Re: Marist Catholic College, 270 Miller Street, North Sydney (SSD-10473)

We write as resident owners at [REDACTED] regarding our concerns about the above proposed Marist Catholic College development.

Title
GA PLAN - BASEMENT ZONE 2

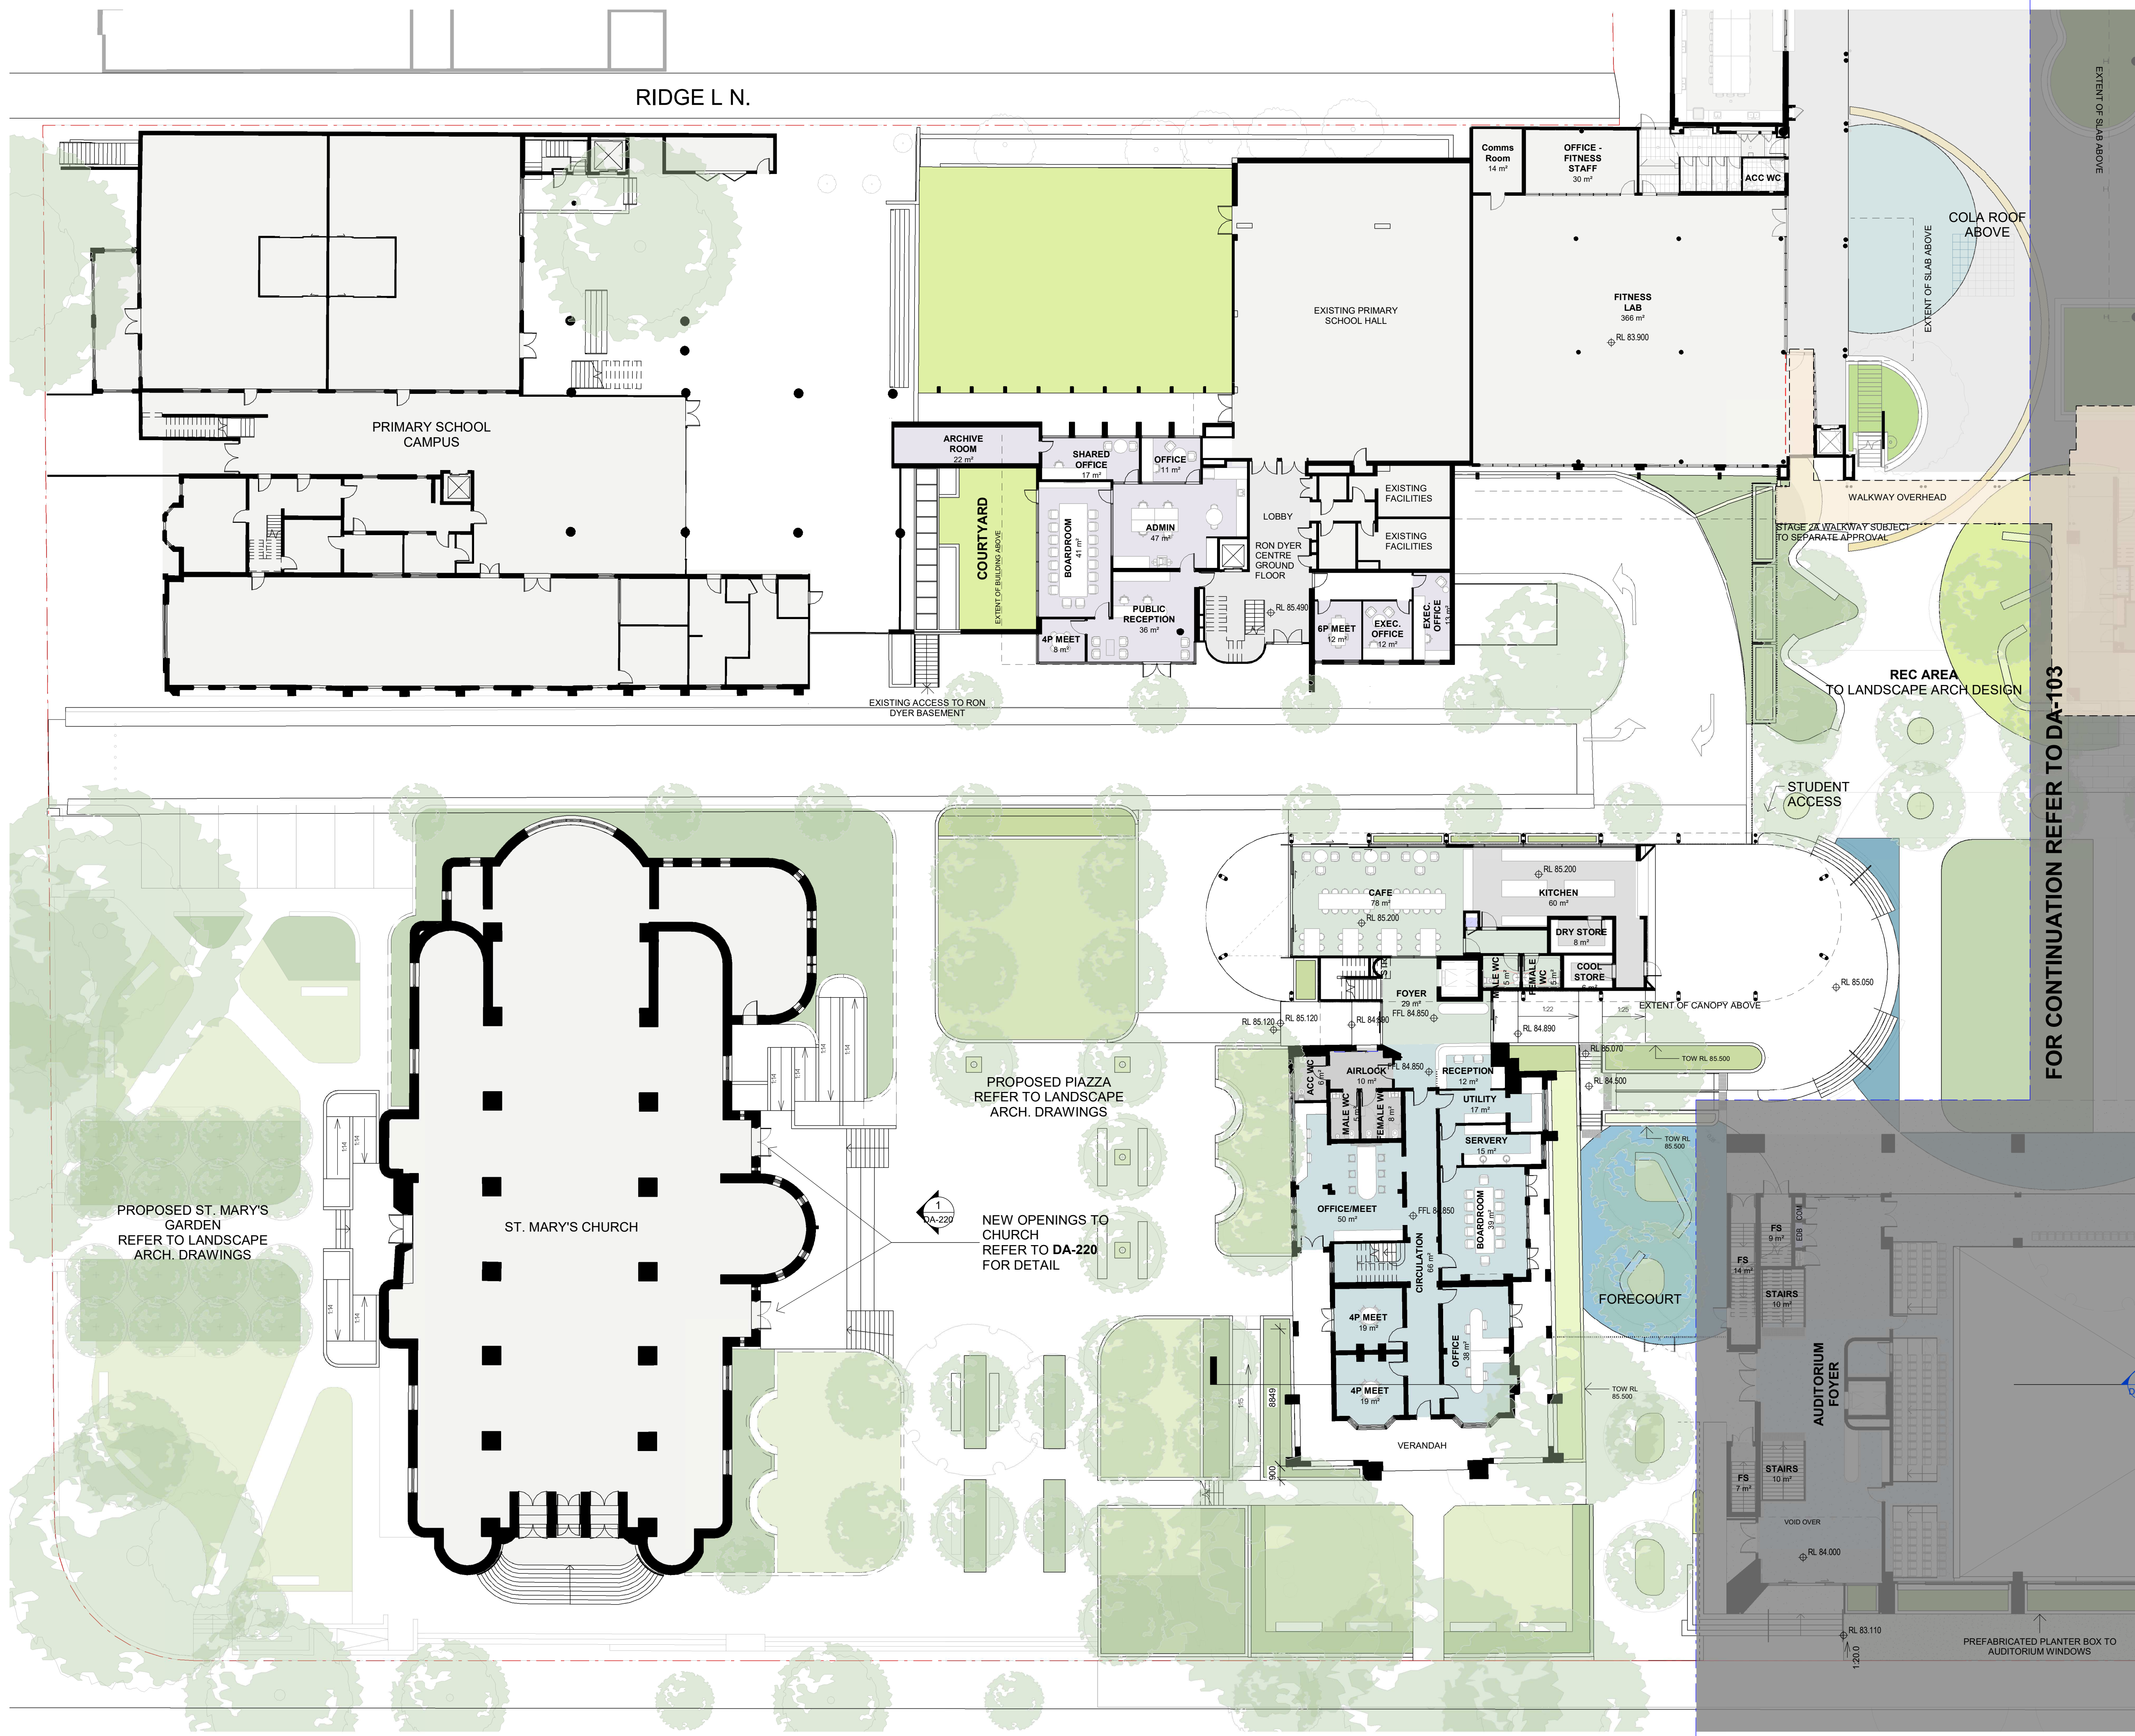
5. We have major concerns about the impact of the proposed new entrance/exit into a new underground drop-off area via Carlow Street. Traffic is already very heavy before and after school hours in all surrounding streets and this will add to the already high levels of congestion, excessive noise and air pollution. Furthermore, we cannot see how the proposed arrangement can do other than create a massive traffic bottleneck in Carlow Street as the exiting cars trying to turn right will be blocked by those seeking to enter, leading to chaos.
